# WINDERMERE PRELIMINARY PLAN

PRELIMINARY  
LANDSCAPE  
EXHIBIT

**LS01**

# LS V\_4.pdf Markup Summary 2-3-2021

LANDSCAPE BUFFER TYPICAL DETAIL 1" = 20'

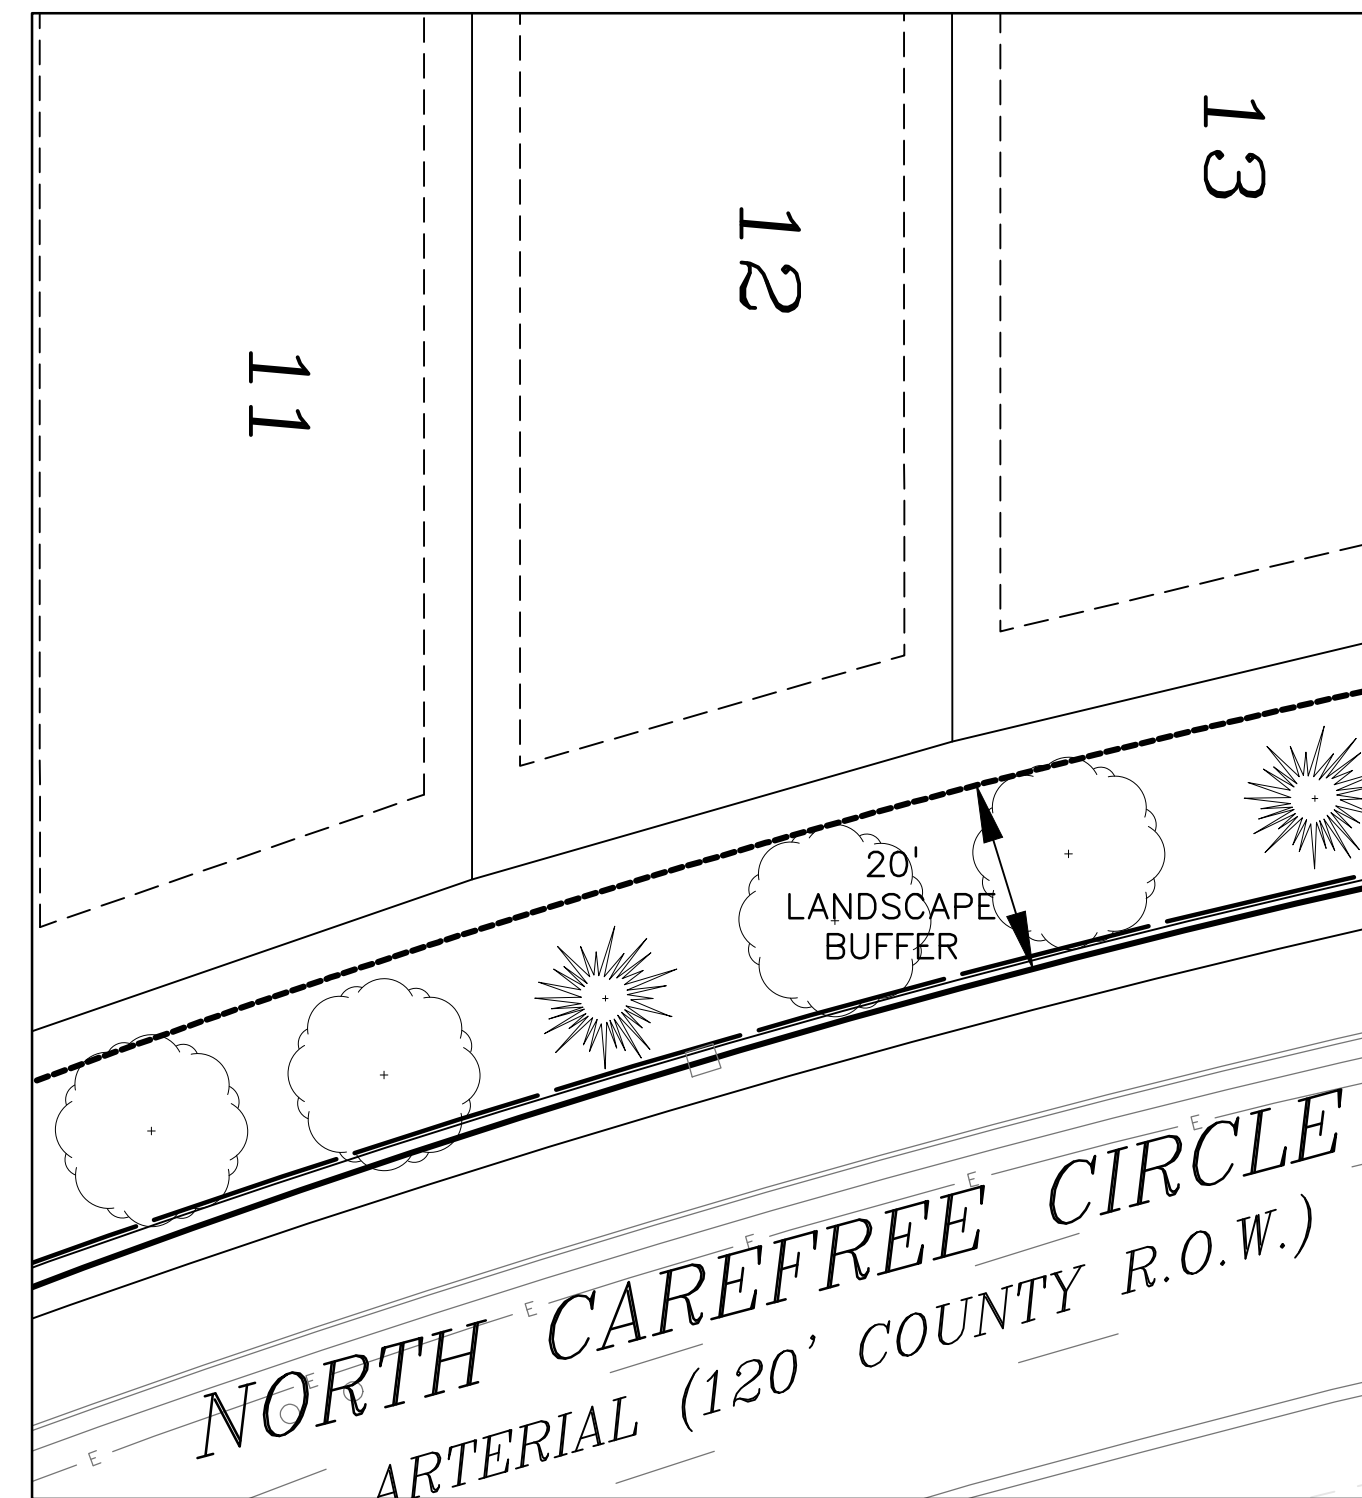
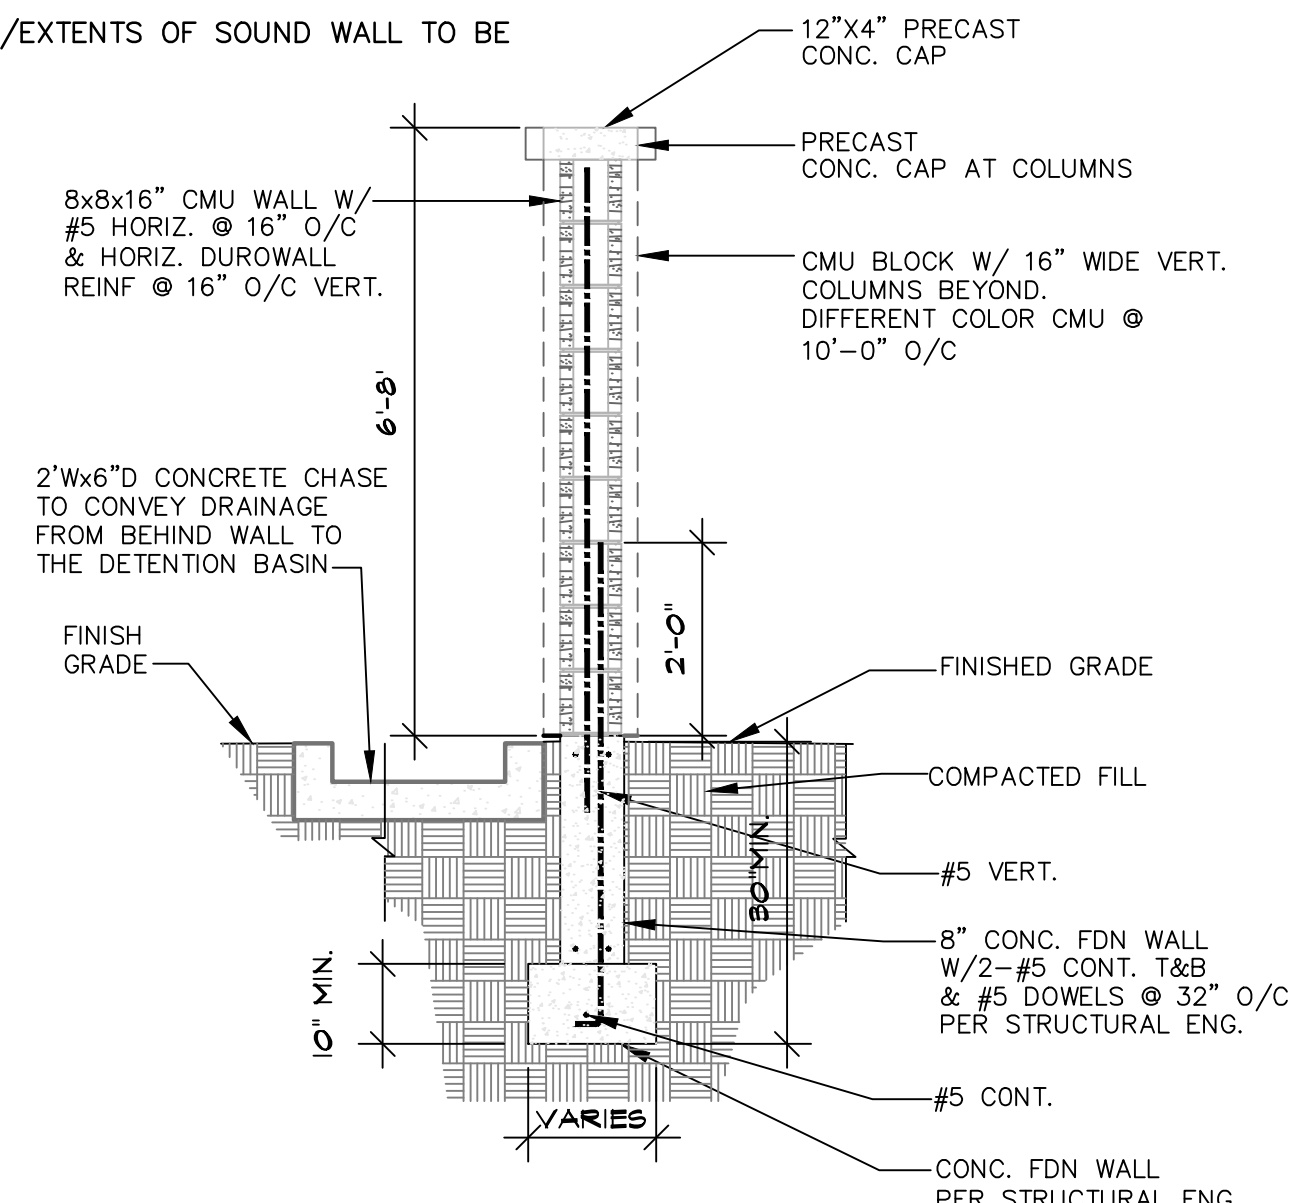
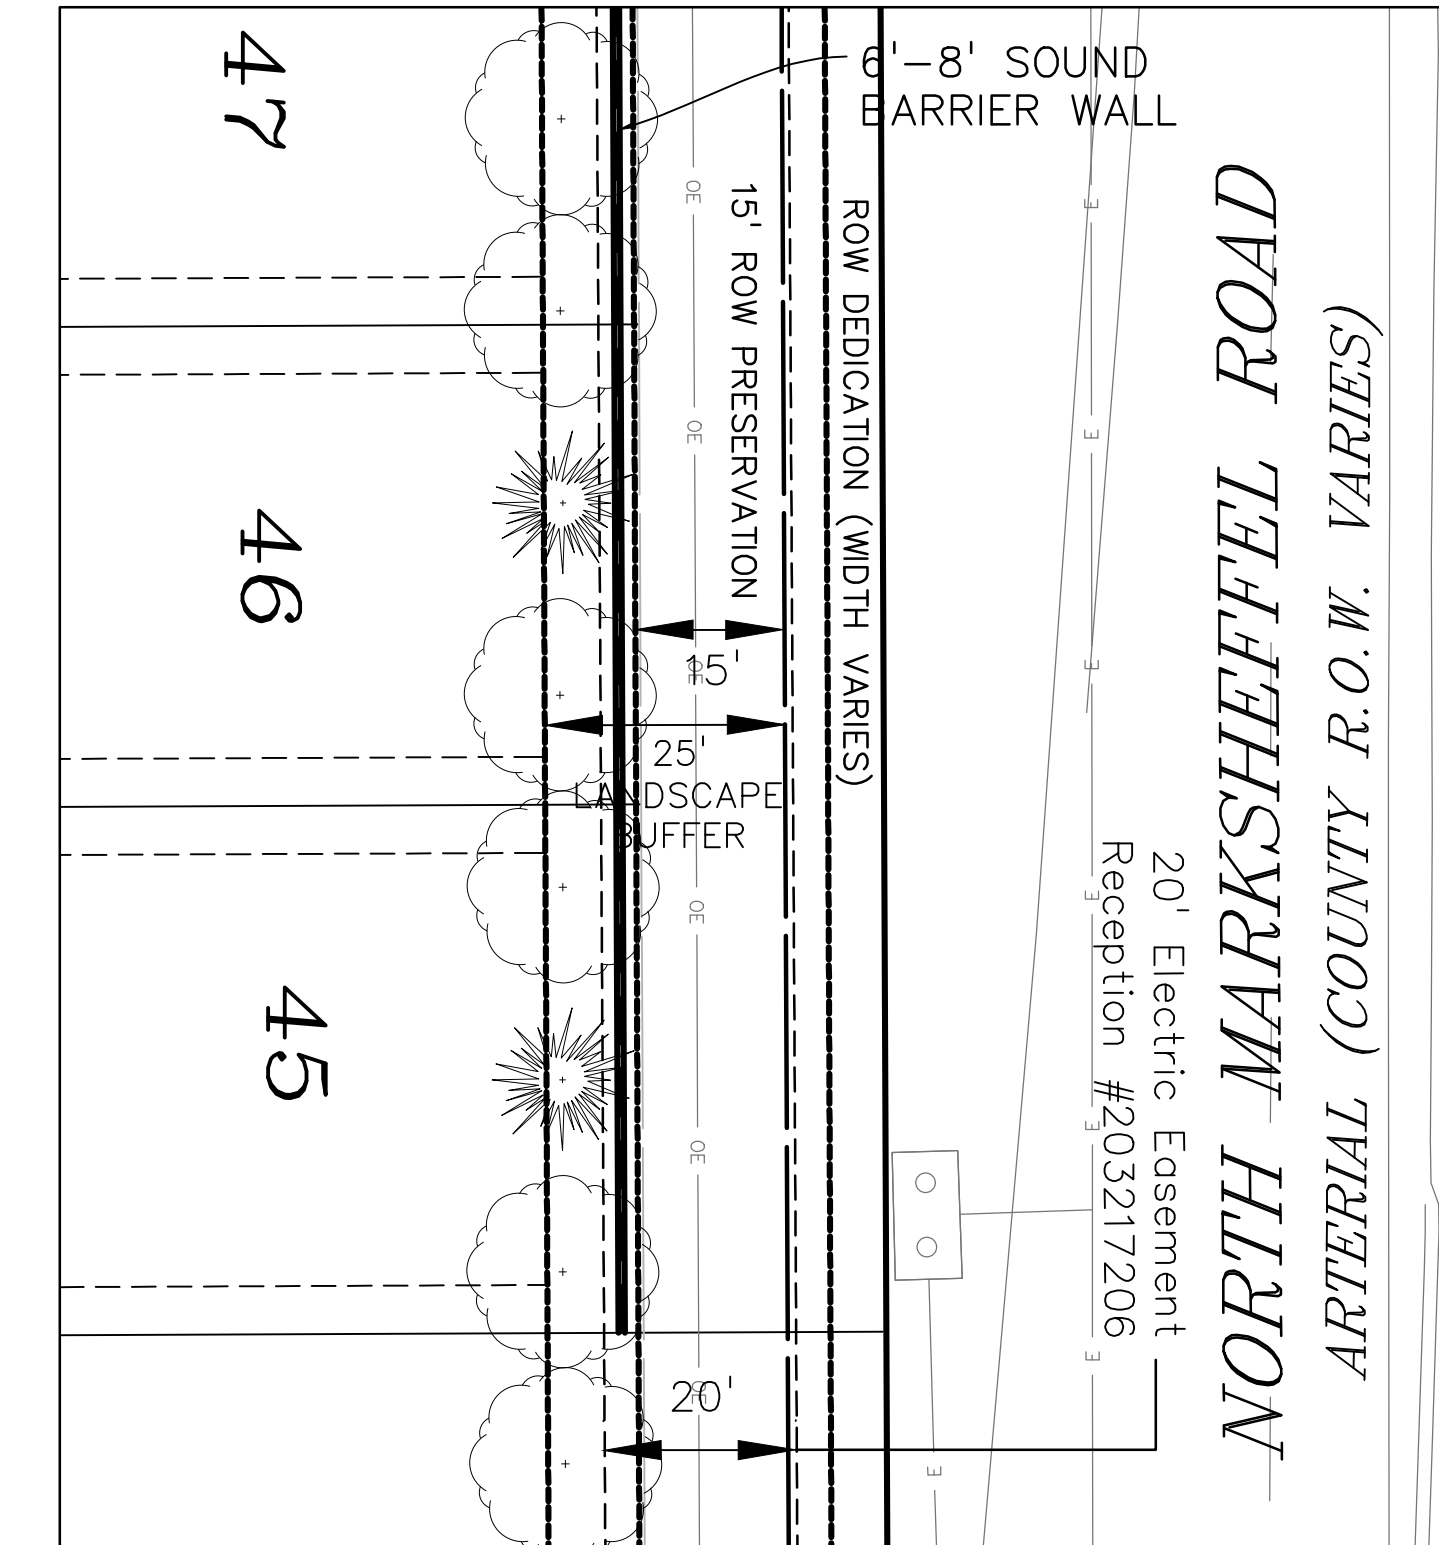
you can always use  
the plant species list  
and detail from  
Falcon Marketplace if  
your at a lost and in  
a hurry with a note  
plant species may  
change with final plat  
and final landscape  
plan.

you will be very tight  
here due to electric  
lines; they wont let  
you place trees there  
so where will you put  
them? Between the  
sound barrier and lot  
line? You will need 6  
feet at least to plan  
B&B 2.5# caliper...  
Show-

add tree symbols and  
species

provide length of  
each linear footage  
and amount of trees  
required of those the  
evergreen required  
per table in Chapter  
6

any trees here?

enlarge details so we  
can see plants
